PLANNING CONSULTATION RESPONSE

Application No	2025/0797
Proposal	Demolition and re-build of existing house with associated work to boundary walls (custom/self build)
Address	Berry Well, Kirkwood Bridge Lane, Spring Vale, Sheffield, S36 6AX
Date of Consultation Reply	26/01/2026
Consultee	BMBC PROW – C Farley

DRAWING TITLE
Existing Site Plan

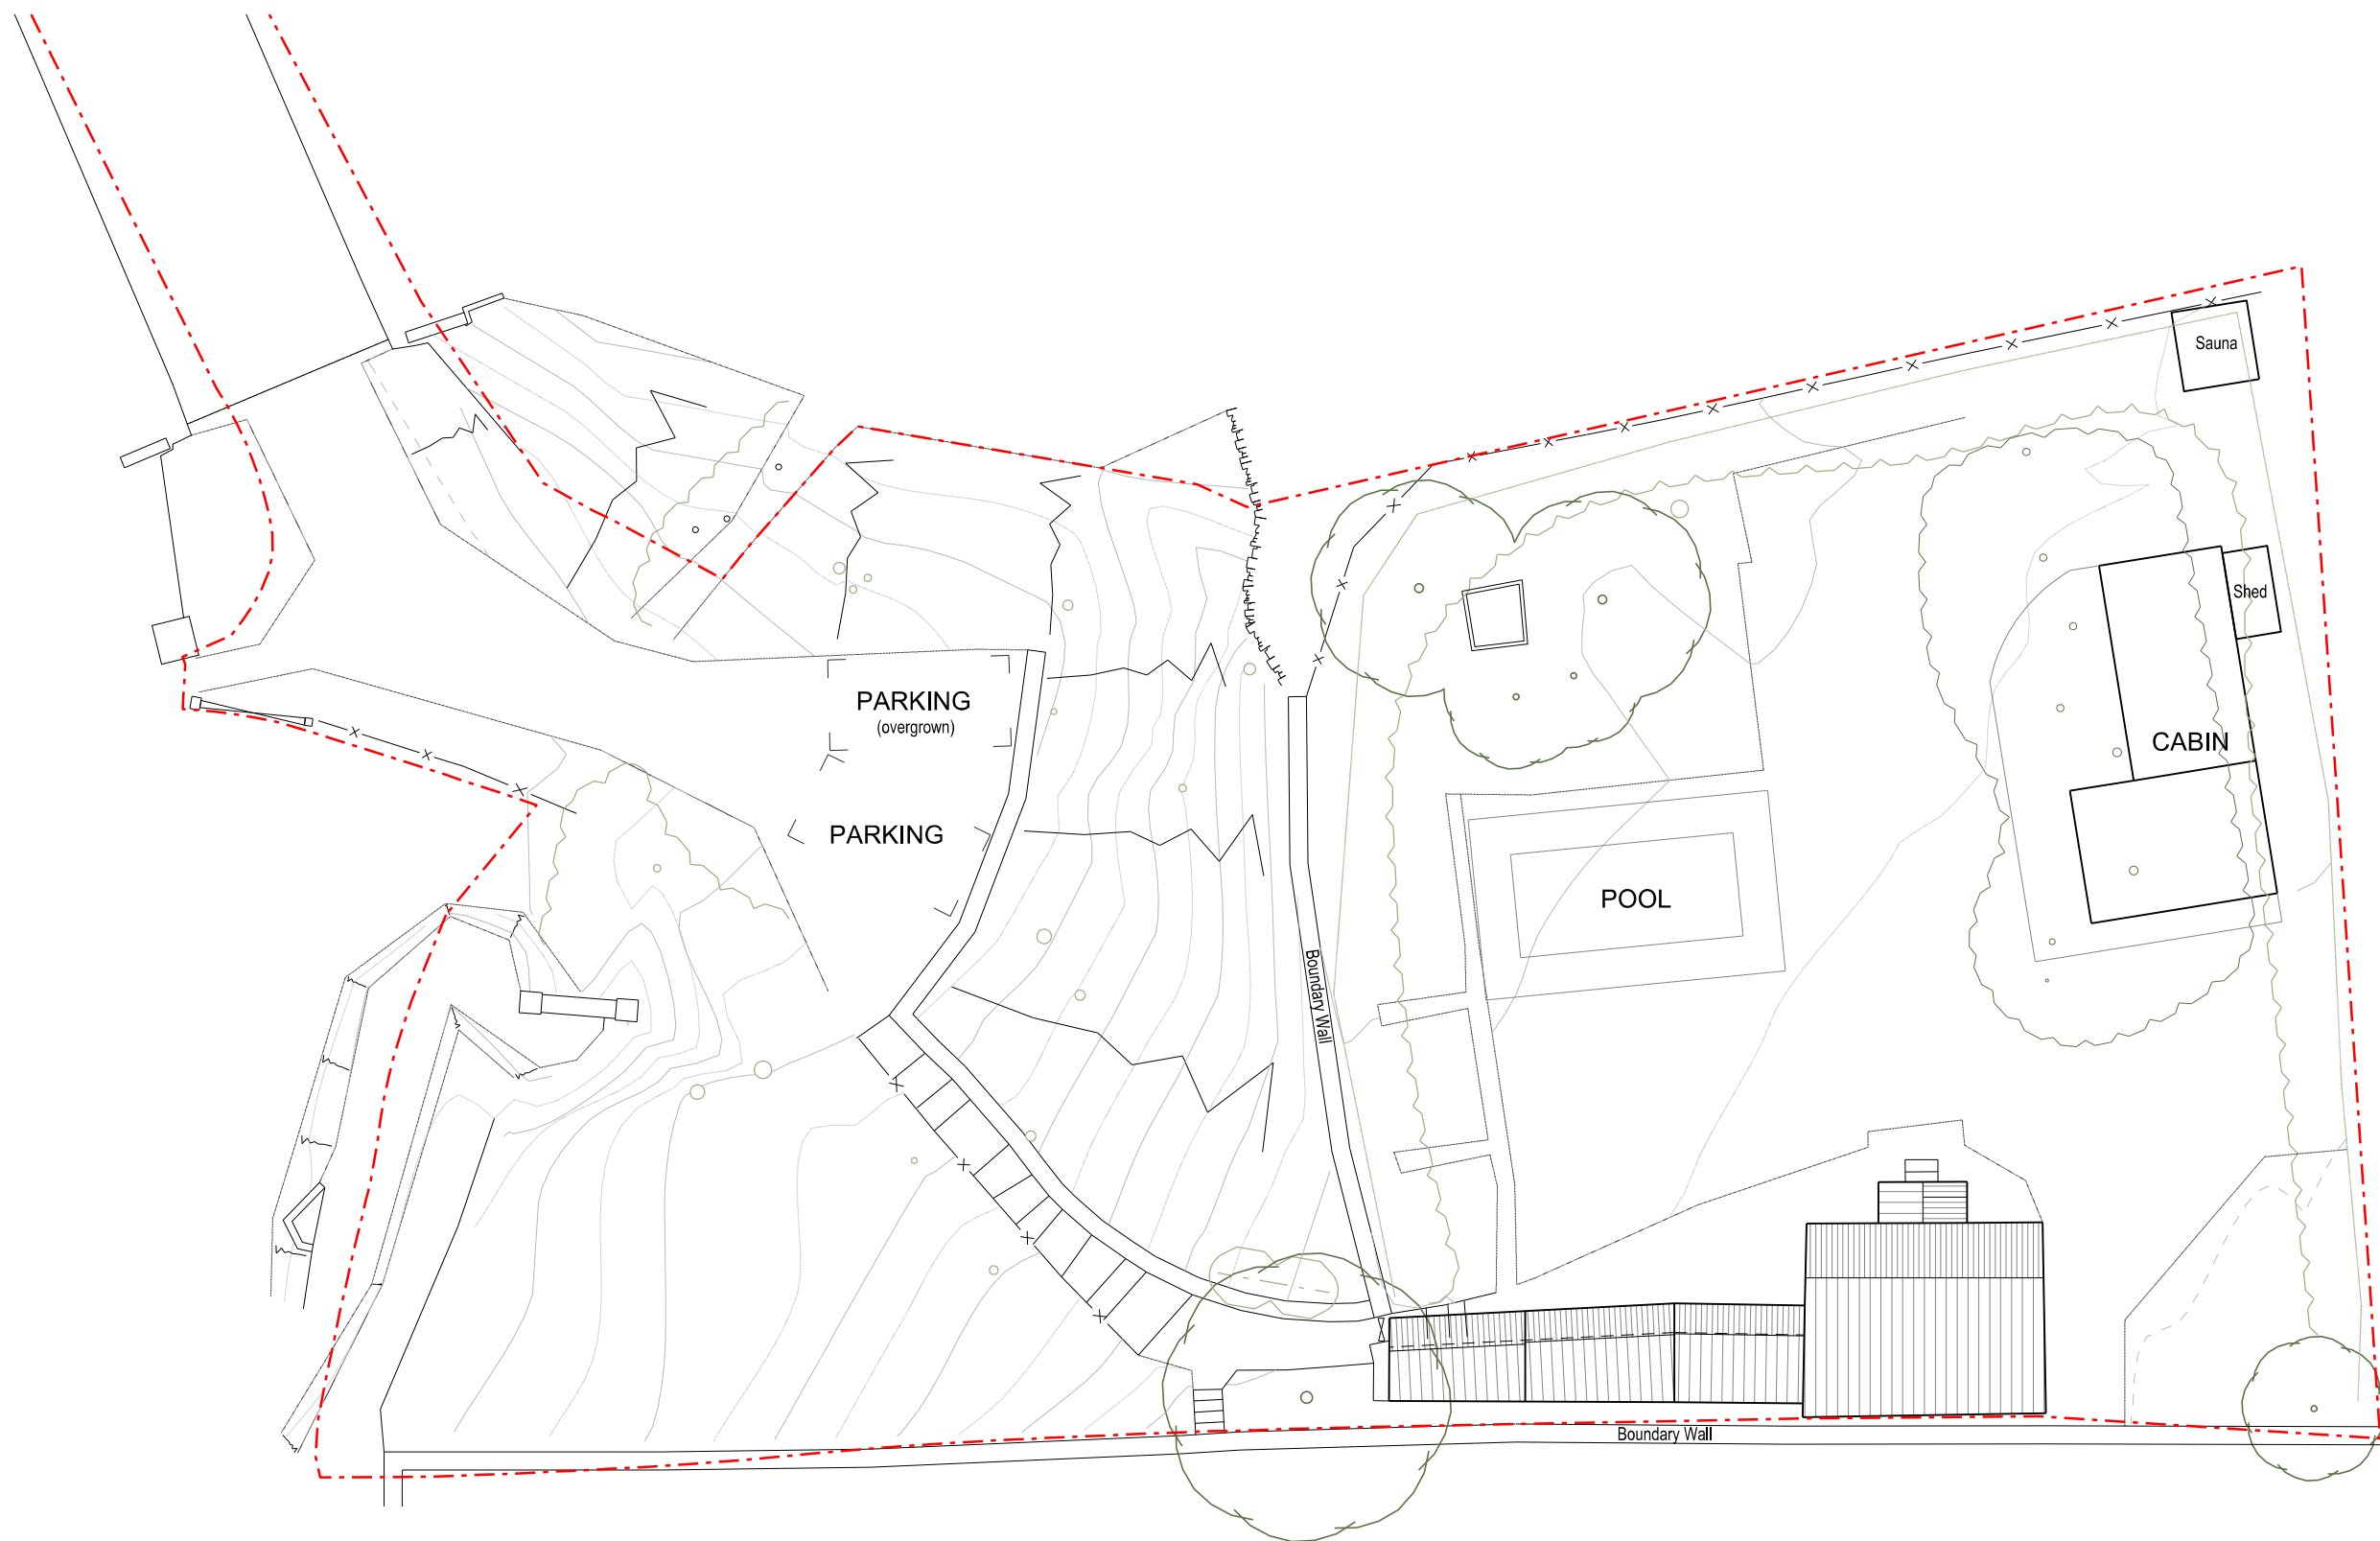
We have concerns regarding site traffic along this very narrow access track and how they propose to turn their vehicles adjacent to the development. In the design and access statement they state it is a little used path. We do not feel this is the case and pedestrians should be protected from site vehicles at all times. If the proposals are approved, we would need assurance that there will be no vehicles parked on the public footpaths and when vehicles are on site, banksmen will be used if reversing up and down the access track to protect pedestrians

A public right of way (Oxspring FP 15) runs along the access track to the proposed development site. Safe public access on the right of way should remain available at all times, with no obstruction of or encroachment onto the width of the path and no building debris, storage of materials or parked vehicles limiting access at any time. Appropriate measures should be taken to protect the public, including banksmen and fencing if necessary. Penistone FP 103 should also be kept clear. If
